Gatwick Airport Northern Runway Project

The Applicant's Response to the Examining Authority's
Written Questions – Air Quality

Application Document Ref: 10.16

DRAWING NO. FIGURE 13.1.11	REVISION For ES Issue
	DRAWN BY MA	PM / CHECKED BY AC

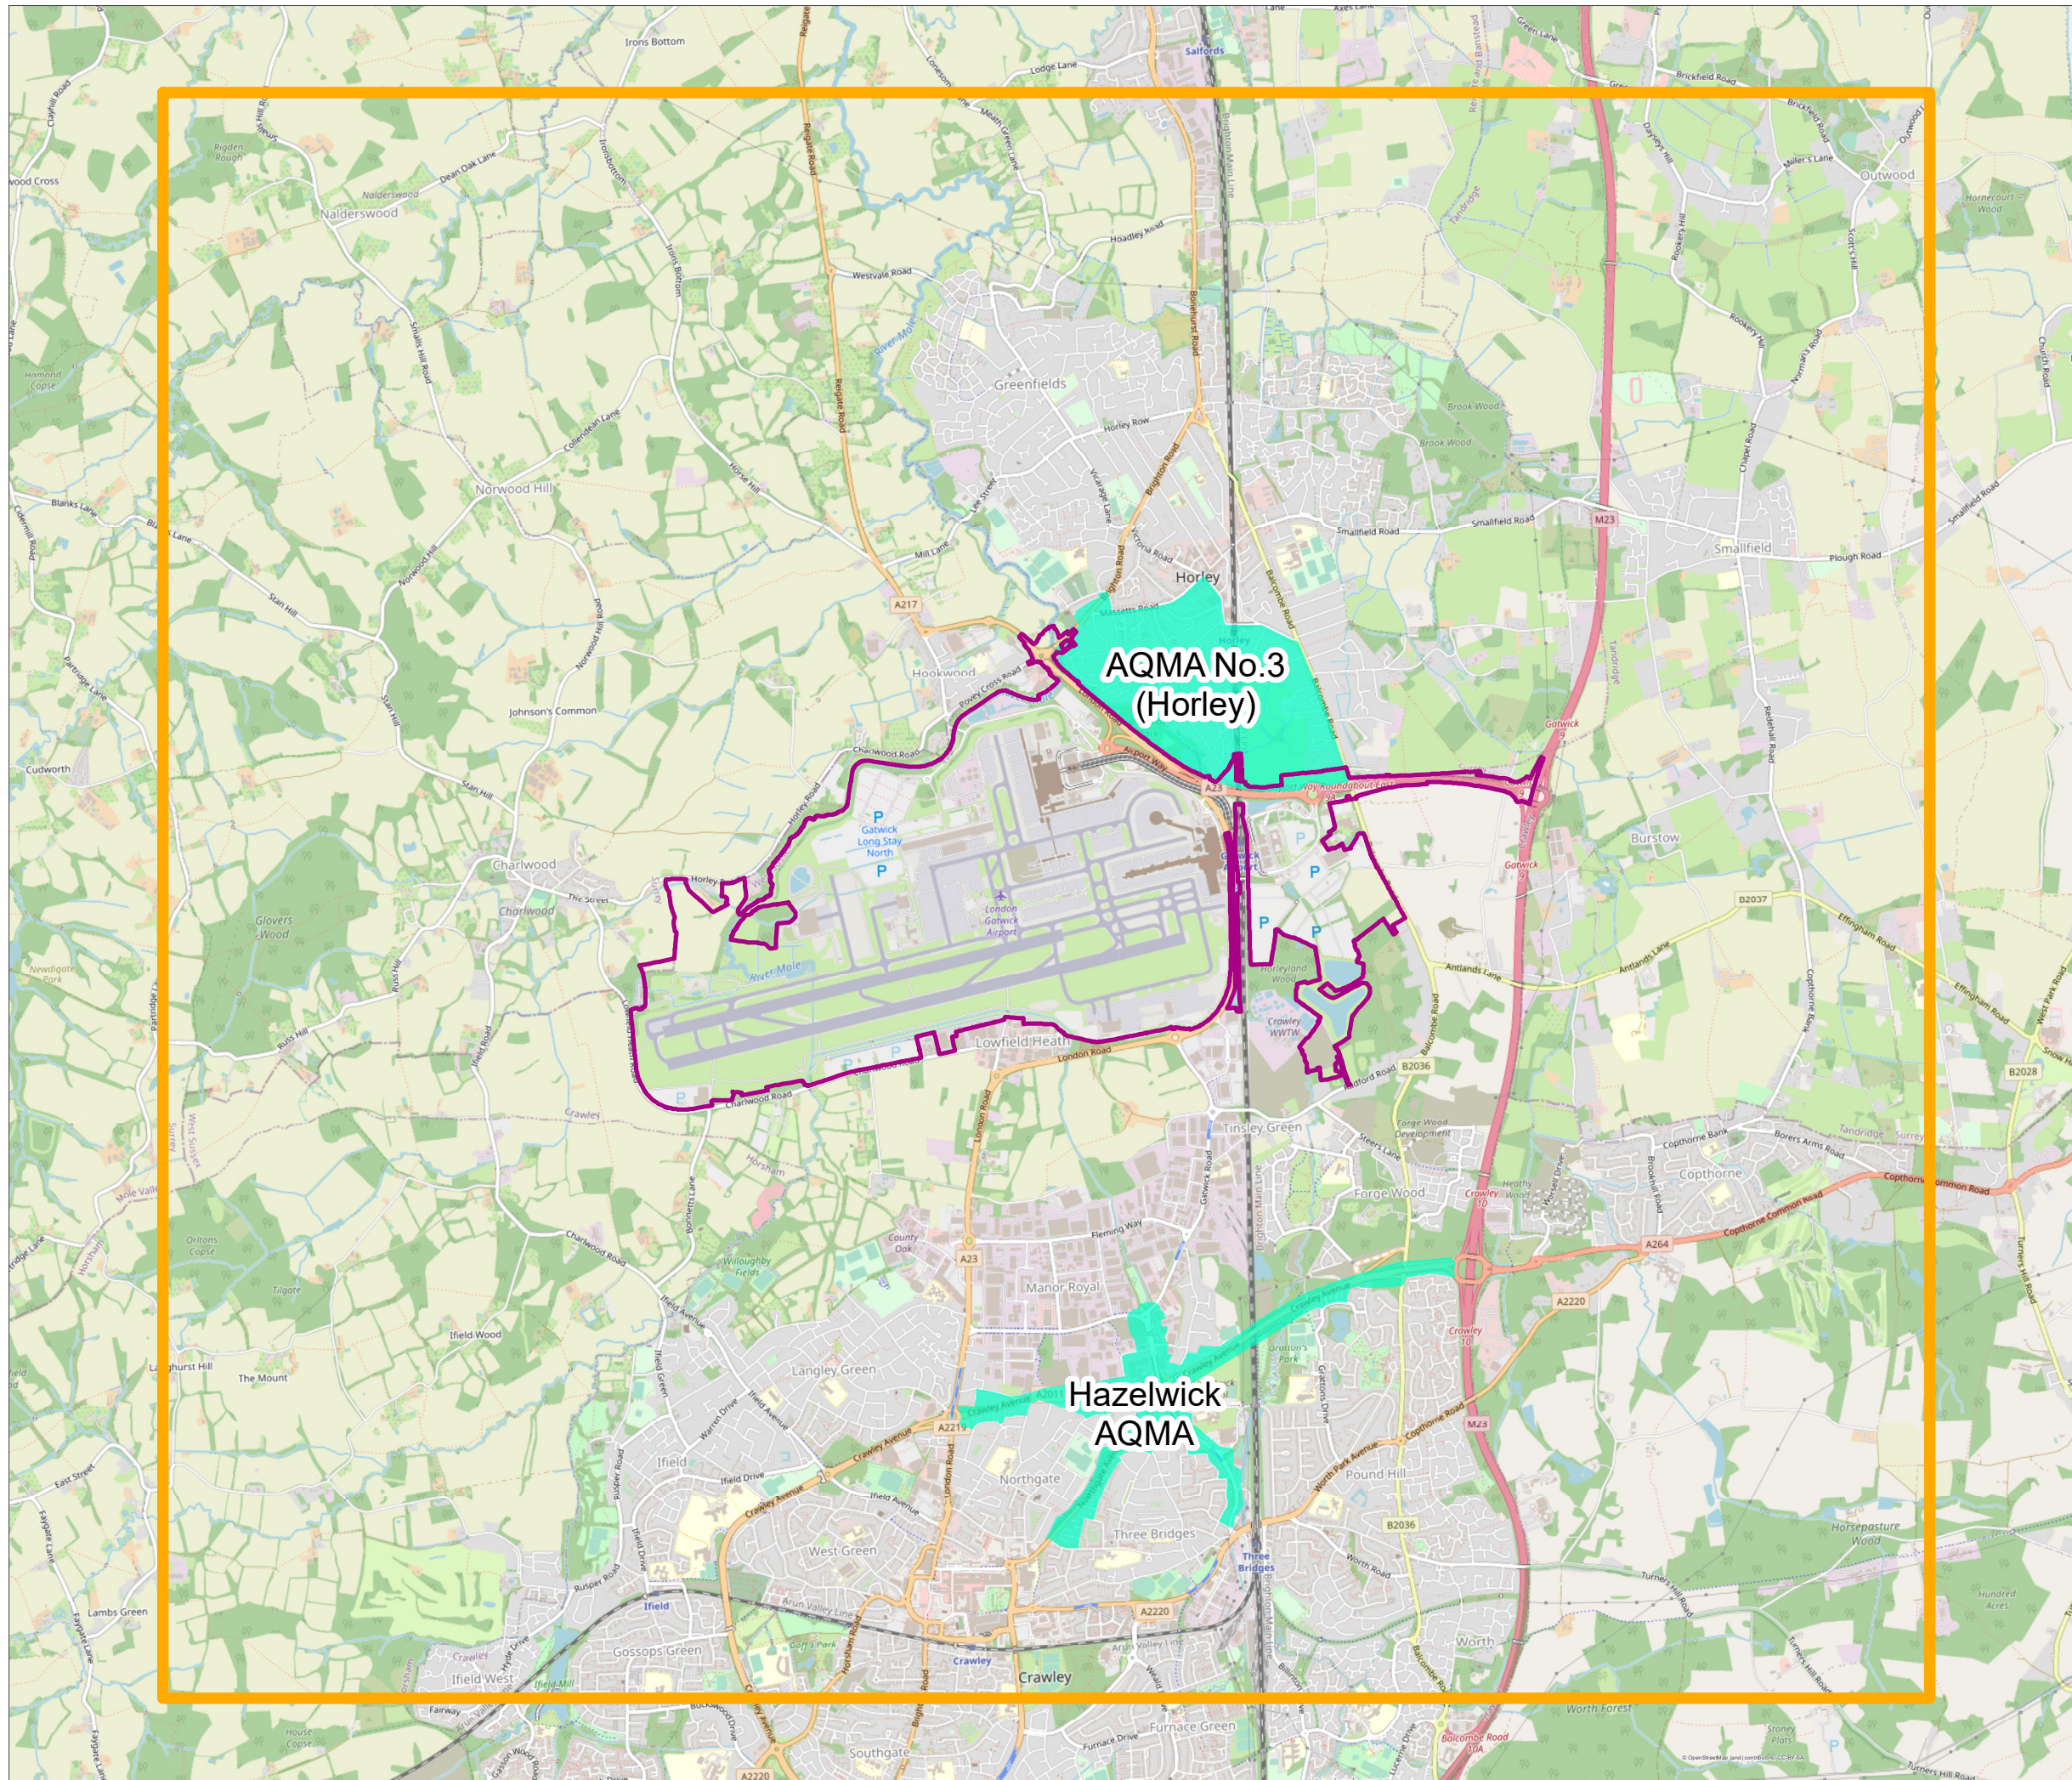
AQ.1.13	The Applicant	<p>Effects on the Hazelwick AQMA</p> <p>ES Chapter 13, paragraph 13.7.2 [APP-038] identifies Horley AQMA and Hazelwick AQMA as the only two AQMAs located within the 10km x 11km study area. Hazelwick extension is stated to be the area where the Three Bridges are, which is an additional area onto the southeastern arm of the current Hazelwick AQMA.</p> <p>These two AQMAs are located in the Air Quality Figures Part 1 on Figure 13.1.11 [APP-066] however, it is not clear whether the extension is included in this Figure.</p> <p>Can the Applicant confirm the location and extent of the Hazelwick AQMA extension in relation to the Proposed Development either in the existing documentation or provide an appropriate Figure?</p> <hr/> <p>The Hazelwick Air Quality Management Area (AQMA) and extension is located approximately 3km south of the Order Limits. The original AQMA was declared on 09/07/2015 for exceedances of the annual mean NO₂ air quality standard. The extension of Hazelwick AQMA was declared on 11/03/2022. Figure 1, below, has been provided below showing the location of the original AQMA (in green) and the extension (in purple). The assessment in ES Chapter 13: Air Quality [APP-038] included the extension area.</p>
